# KITTTITAS COUNTY COMMUNITY DEVELOPMENT SERVICES

RE: VA-19-00001 Berlin – Deemed Incomplete and 2<sup>nd</sup> Request for Additional Information

Kittitas County Community Development Services (CDS) received your request for a Zoning Setback Variance on February 28, 2019 to reduce the rear yard setback to 15' from 25' for the construction of a single family residence. The subject property is zoned Residential. This parcel is located at 50 Kitzbuhel Place, in a portion of Section 15, T22N, R11E, WM in Kittitas County, bearing Assessor's map number 22-11-15-050-0005. On March 18, 2019, a request for additional information was sent to you. On March 20, 2019, additional documentation was received. After review of the submitted materials, we have made the following preliminary findings.

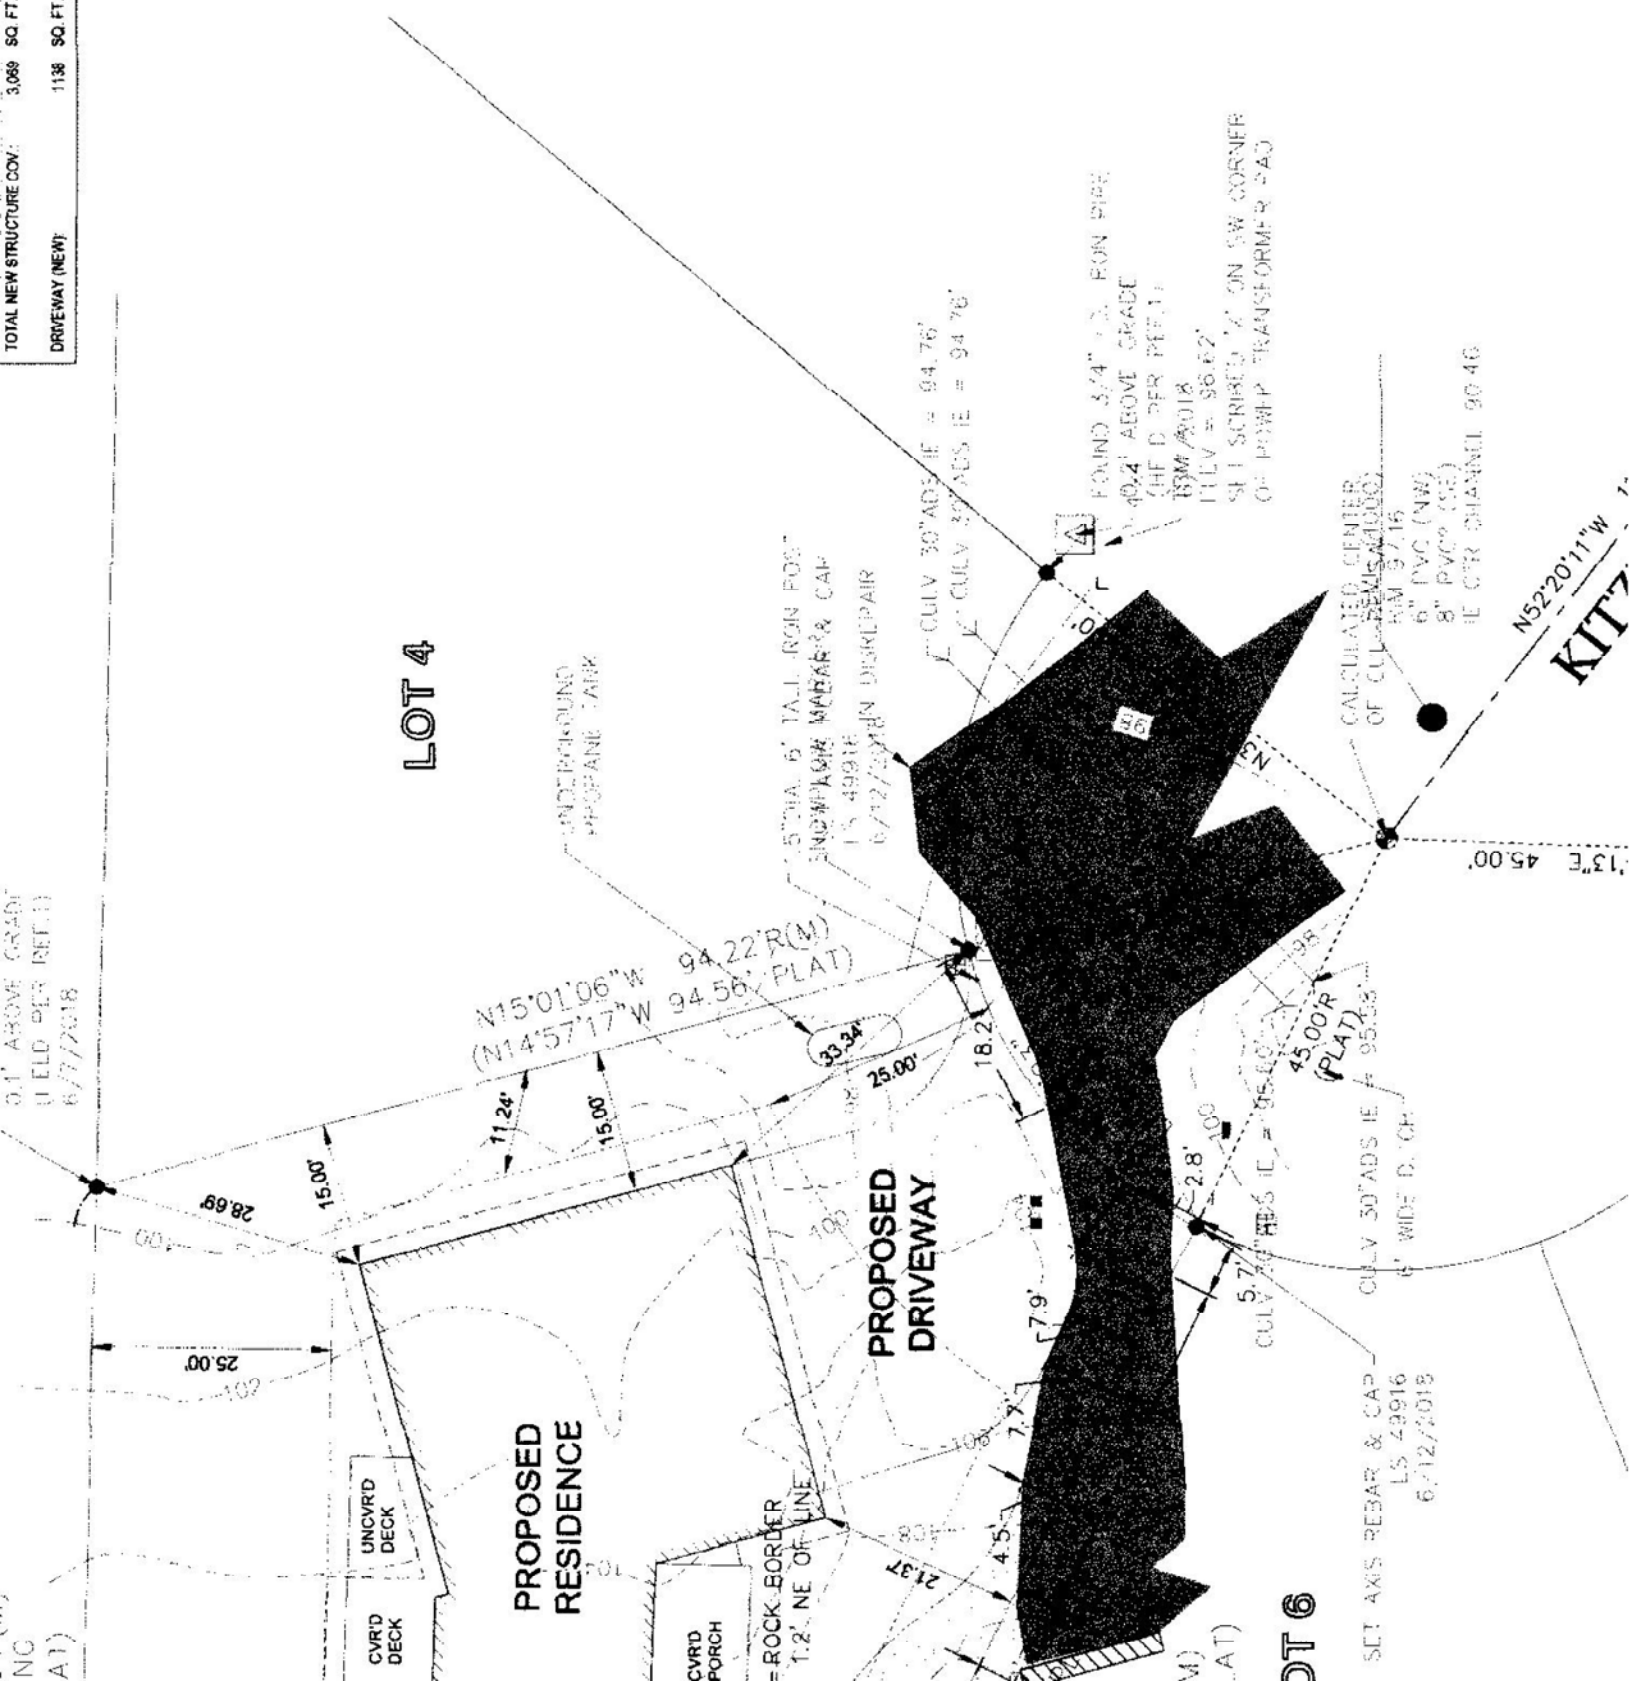
1. A 2<sup>nd</sup> version of the site plan depicting the existing setbacks under current code, for the proposed development so that CDS may review the “*proposed use and its relationship to surrounding properties*”, pursuant to KCC 15A.03(2) above. The current setbacks under current code are as follows: 15 feet on the front yard, 5 feet on the side yard, and 25 feet on the rear yard, and can be found in KCC 17.16.060-080. This was previously requested in our March 18, 2019 letter (see attached).
2. A revised narrative detailing how the application meets the criteria for KCC 17.84.010(1) - (2).

A1.0

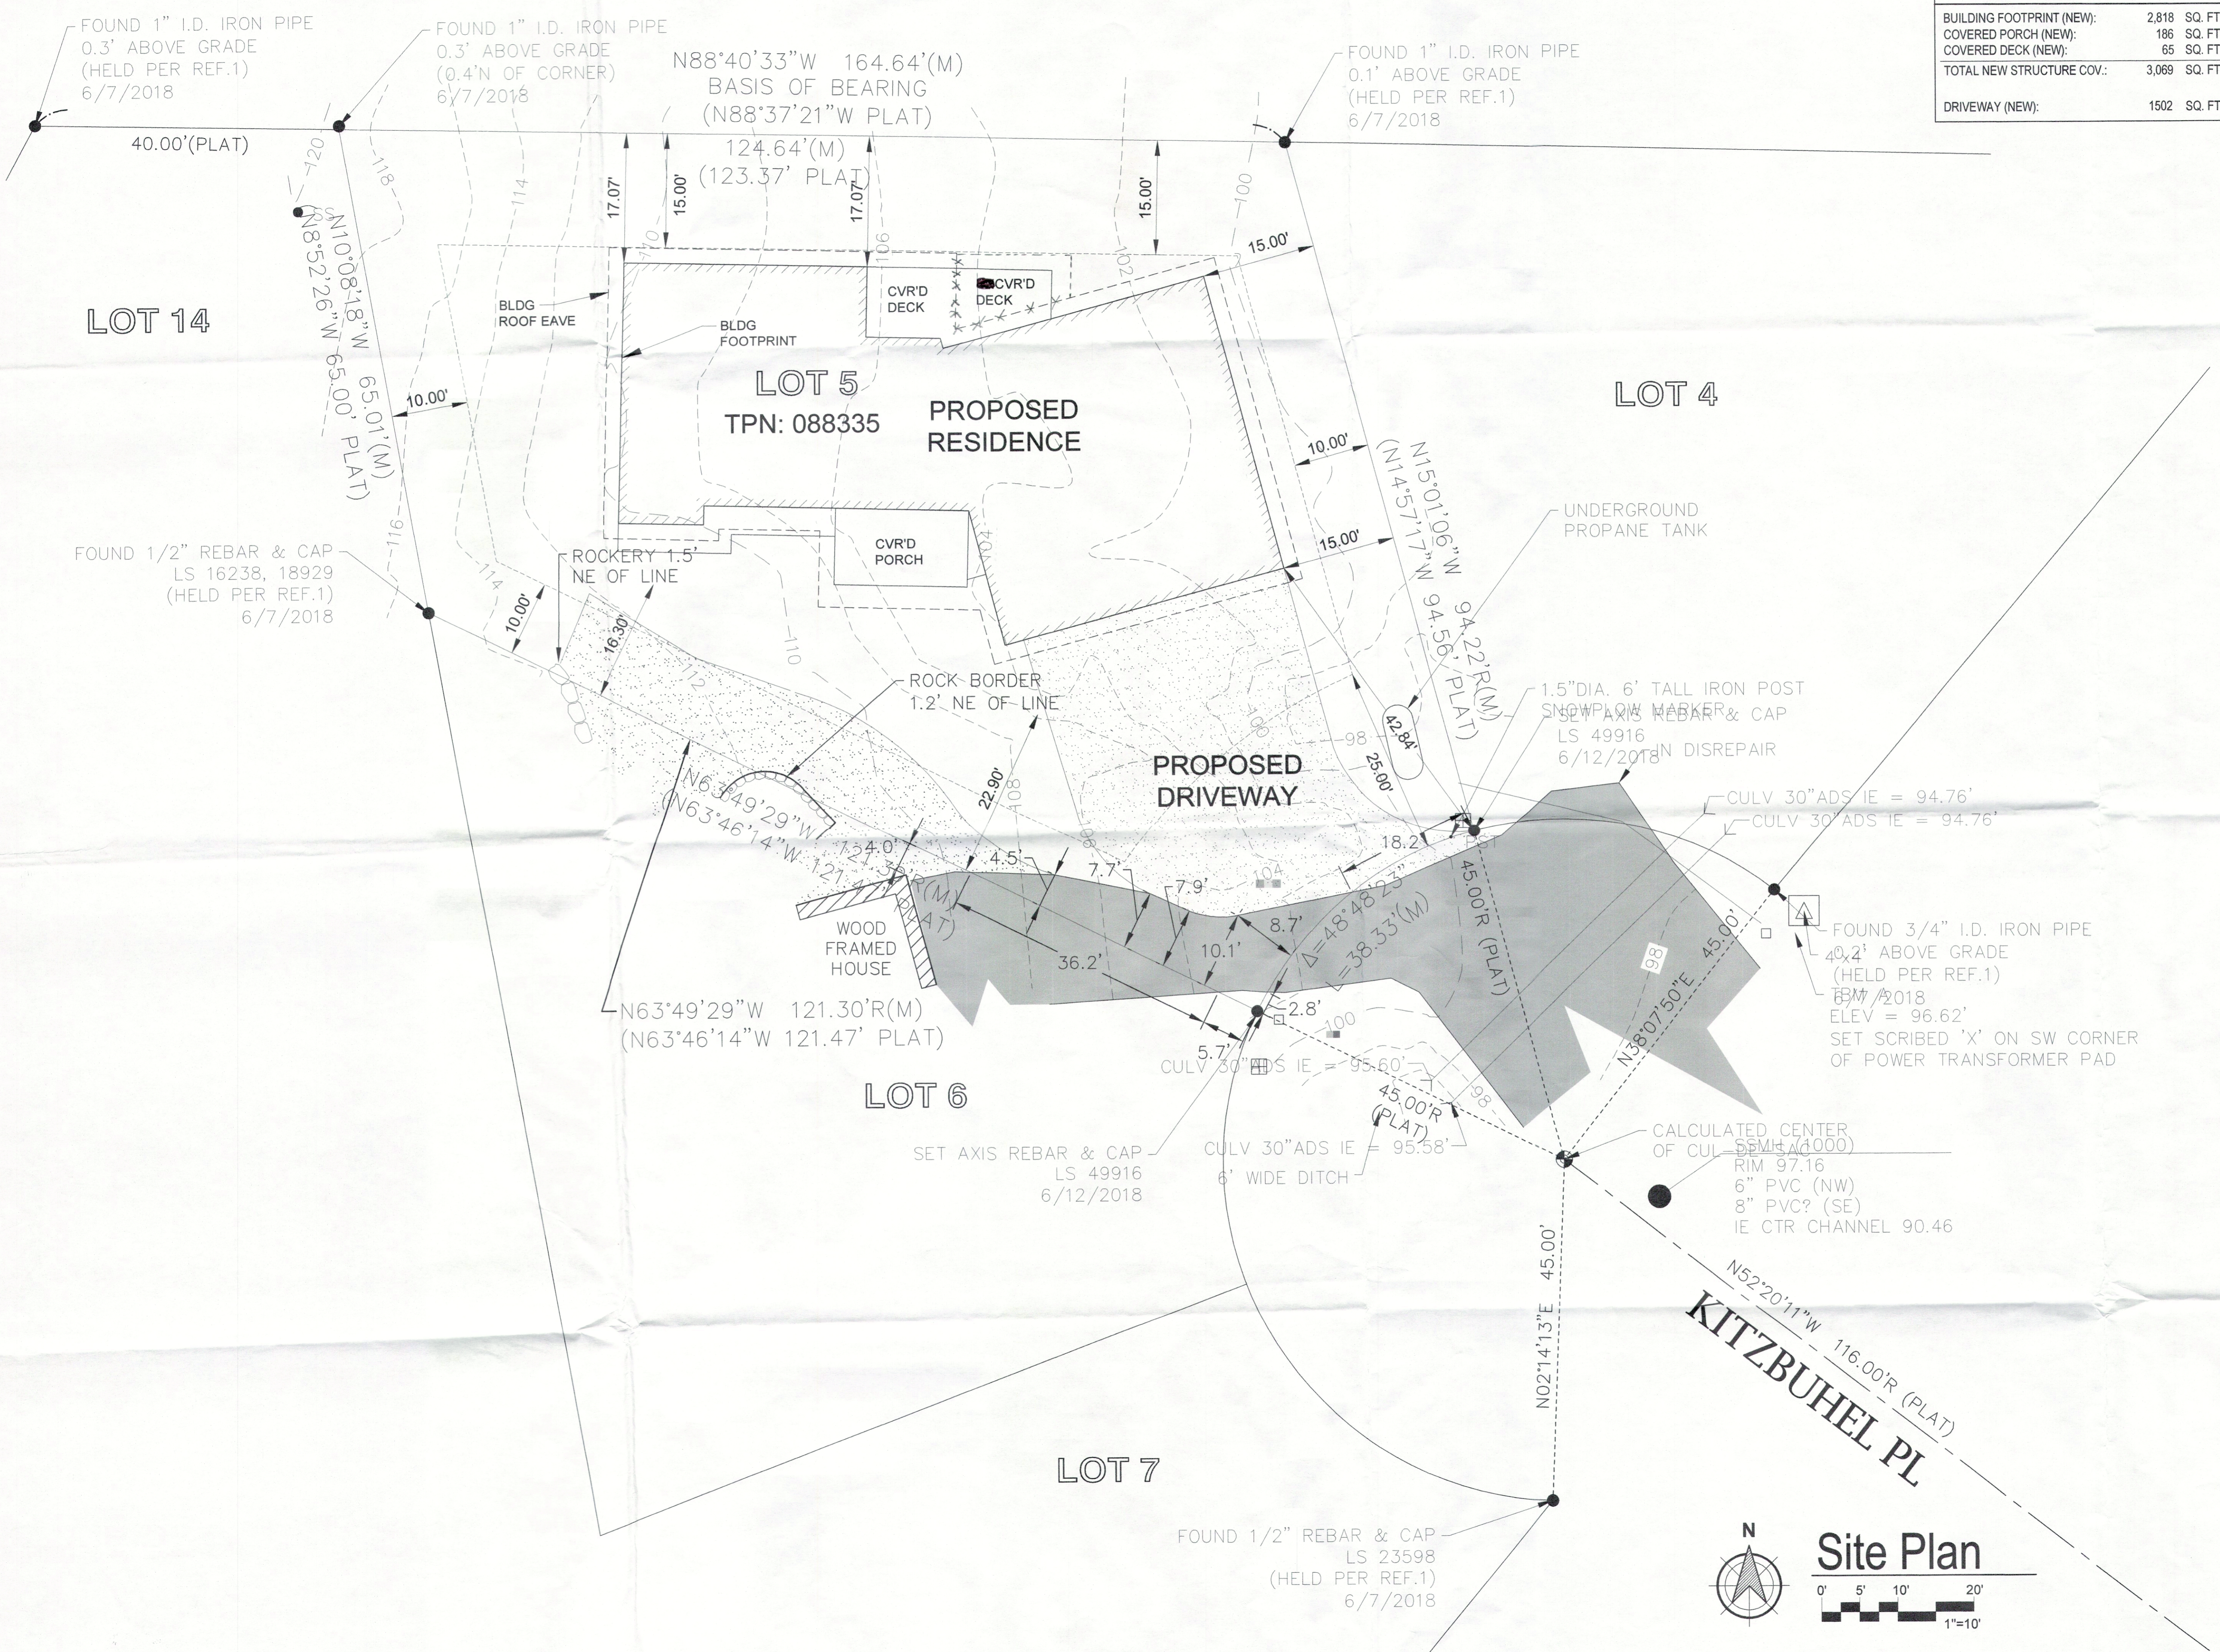
- 1) The subject property is larger in area than most of the surrounding properties, and contains sufficient area to construct a single family residence while adhering to the required rear yard setback. The proposed 2818 square foot footprint for the proposed residence can be reduced in size to accommodate the setback in code, even if the neighbor's encroachment onto the property is considered.

- 2) The proposed residence has a larger footprint than the surrounding properties. The right to build a residence similar in area to the neighboring properties is not infringed by the property line setbacks existing in code.

1. A revision to the site plan depicting the square footage of the proposed structure, in order to determine the proposal's consistency with the comprehensive development pattern of the area pursuant KCC 17.84.010(4) above.
2. A revision to the site plan depicting the existing setbacks under current code, and the setbacks (including reduction) for the proposed development so that CDS may review the "proposed use and its relationship to surrounding properties", pursuant to KCC 15A.03(2) above.

TOPOGRAPHIC & BOUNDARY SURVEY
OF
LOT 5 HYAK ESTATES DIVISION 1
(50 KITZBUHEL PL)

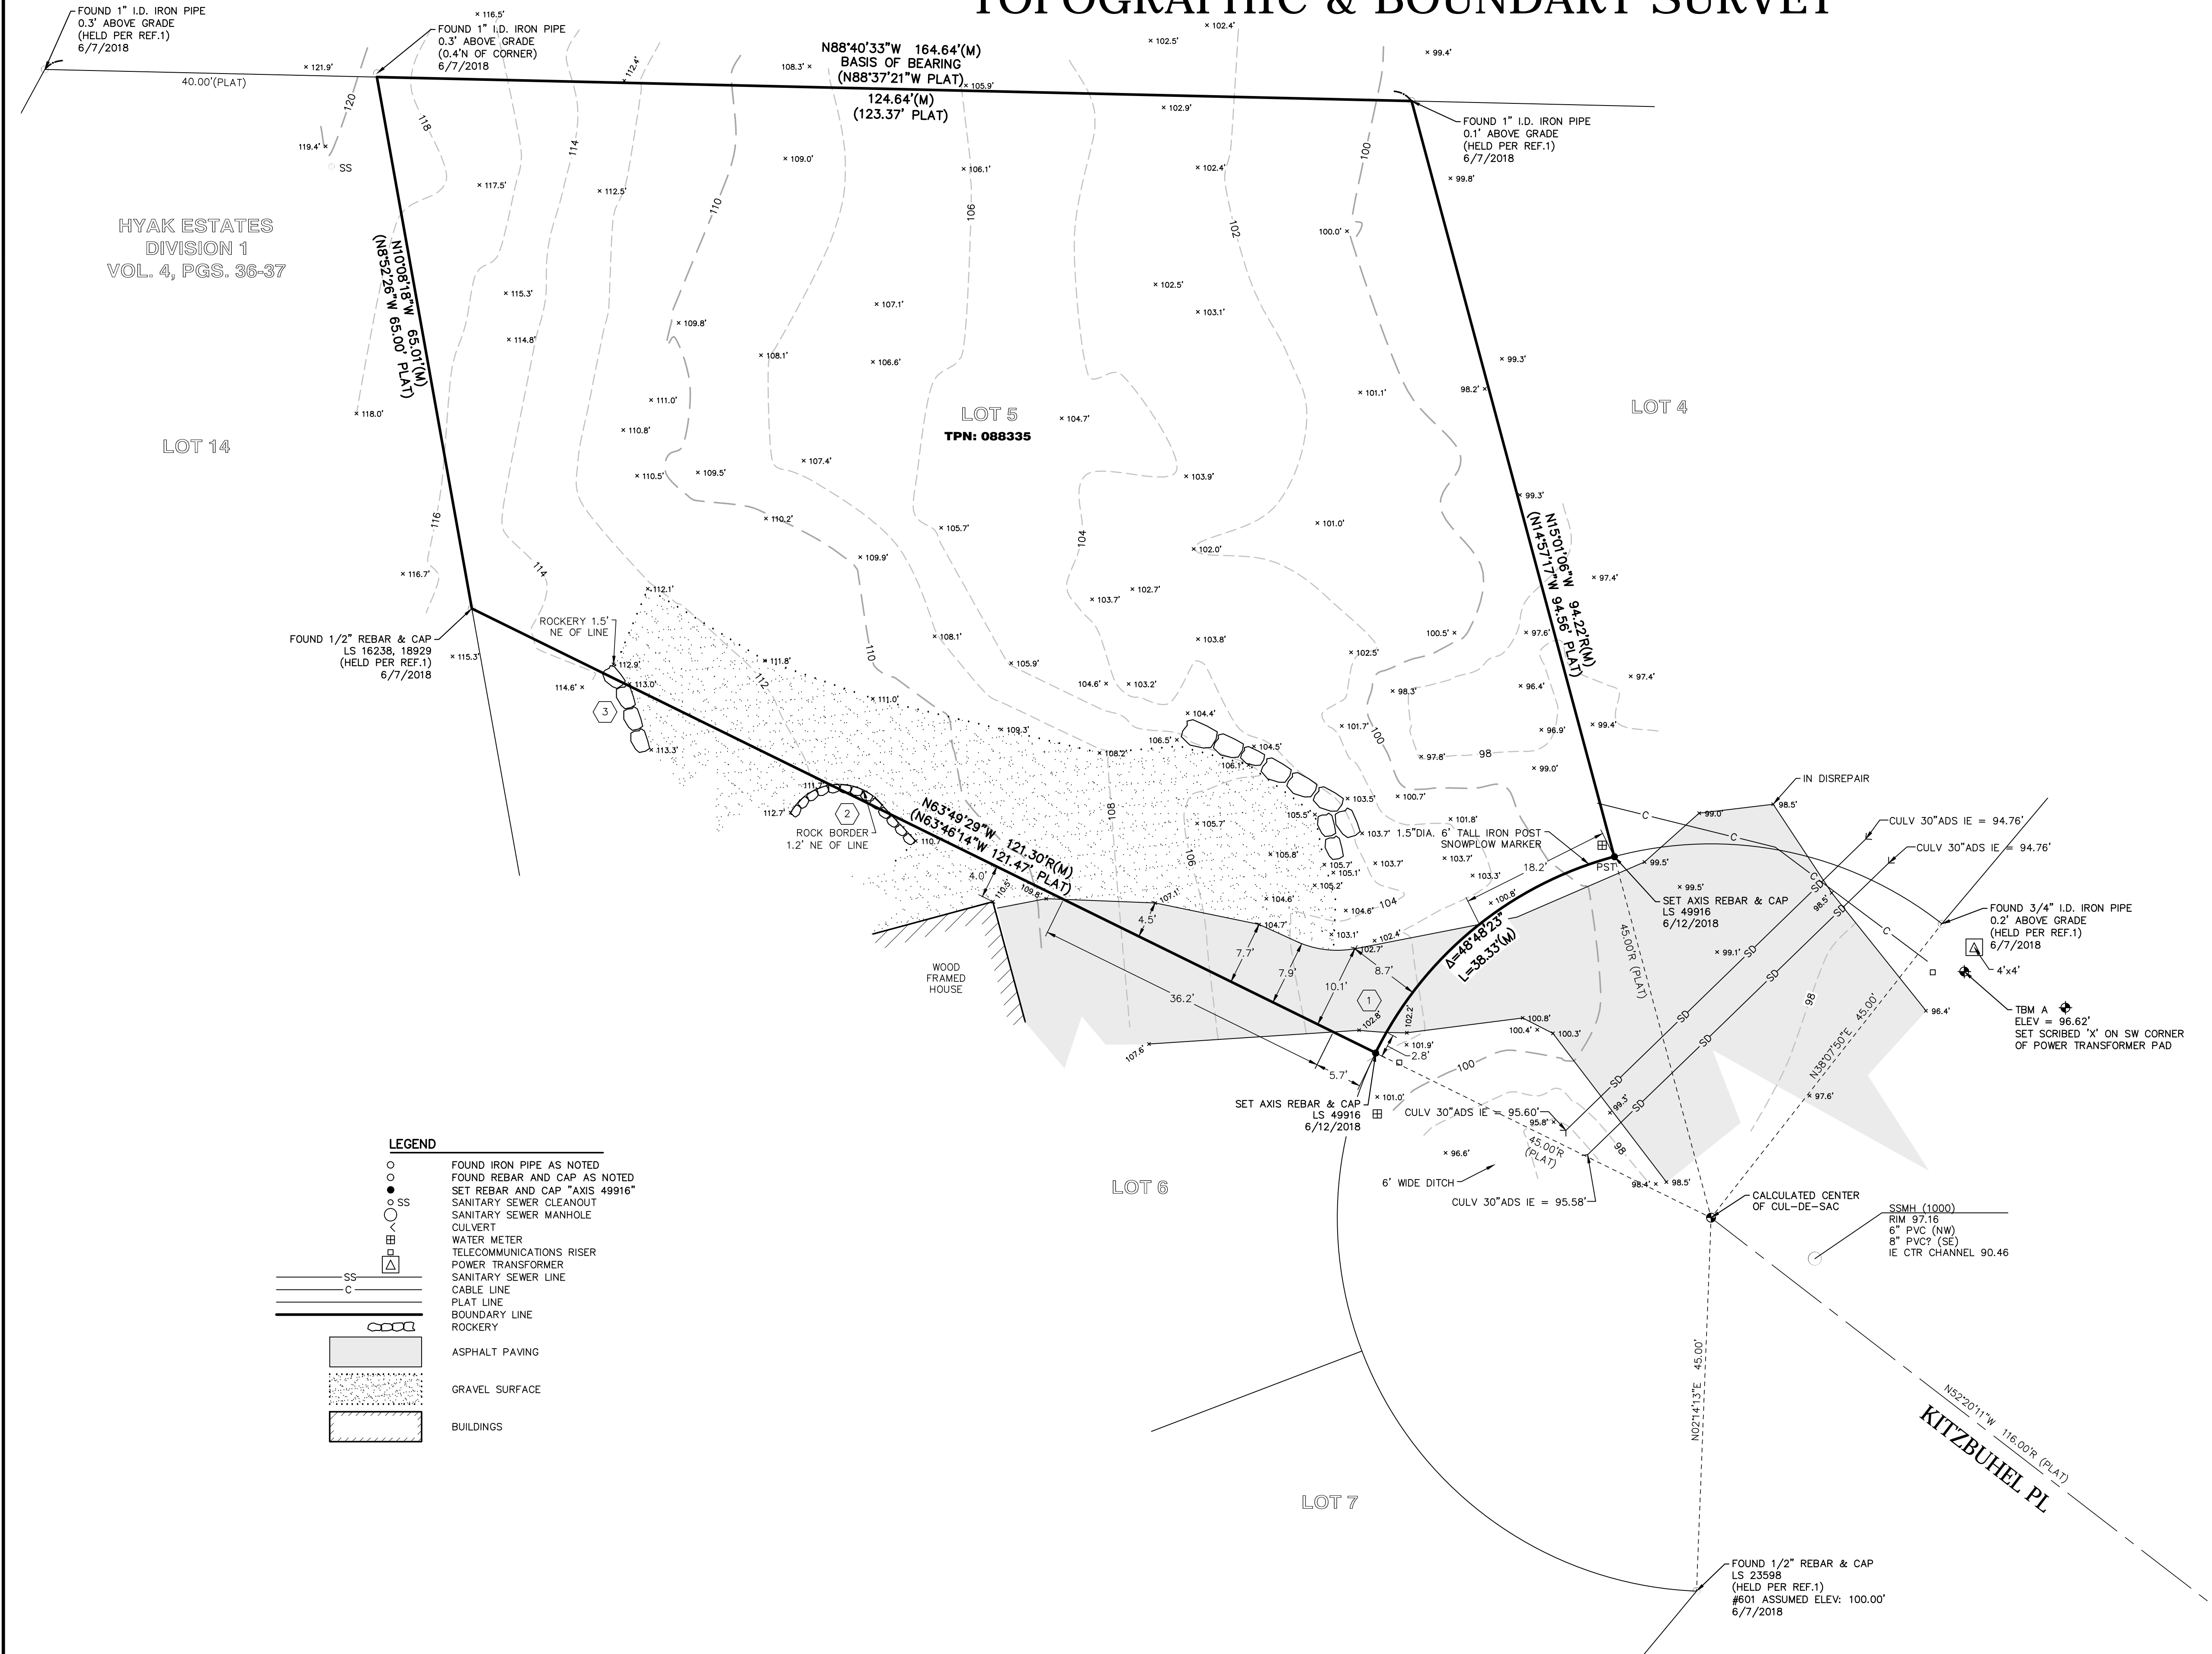
3. Provide additional information regarding the neighbor's "encroaching" driveway and rockery, also pursuant to KCC 15A.03.030(2). Was this "encroachment" discovered by a professional surveyor? If so, please provide a copy of the survey. Is there an existing easement for the driveway and rockery in question? If so, please provide documentation.
